**Sent:** 12 February 2026 09:56  
**To:** Ellie Thornhill <Ellie.Thornhill@kirklees.gov.uk>  
**Subject:** Objection - Planning Application Ref: 2025/62/93480/W

**RE: Planning Application Ref: 2025/62/93480/W**

I am writing to formally object to the proposed planning application **2025/62/93480/W** relating to the proposed housing estate at **Land off Parkwood Road/Weavers Lane, Longwood, Huddersfield, HD3 4TT**.

| TITLE | Detailed Landscape Proposals | | |

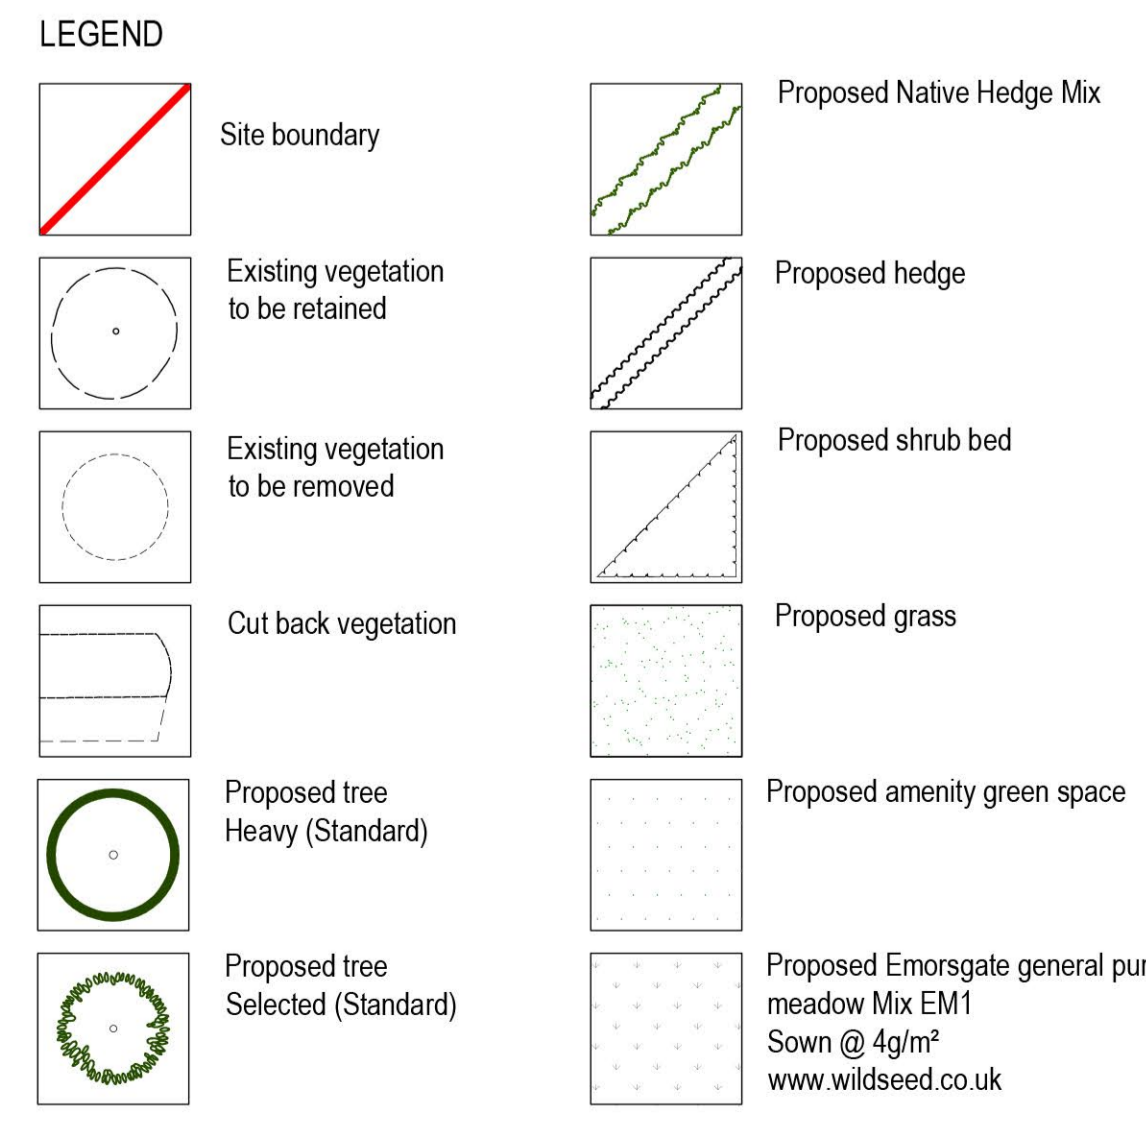
- The layout shows very limited green and open space for a development of this scale. This appears inconsistent with Local Plan policies on green infrastructure and urban green space, which seek to protect, enhance, and provide accessible green areas as part of new development.
- Policy requirements relating to urban green space, open space provision, and wider green infrastructure networks expect developments to deliver meaningful, functional, and accessible green areas that contribute to health, biodiversity, and visual amenity. The current proposal appears to fall short of these standards, regardless of the suggested contribution to other green spaces as part of a Section 106 Agreement.
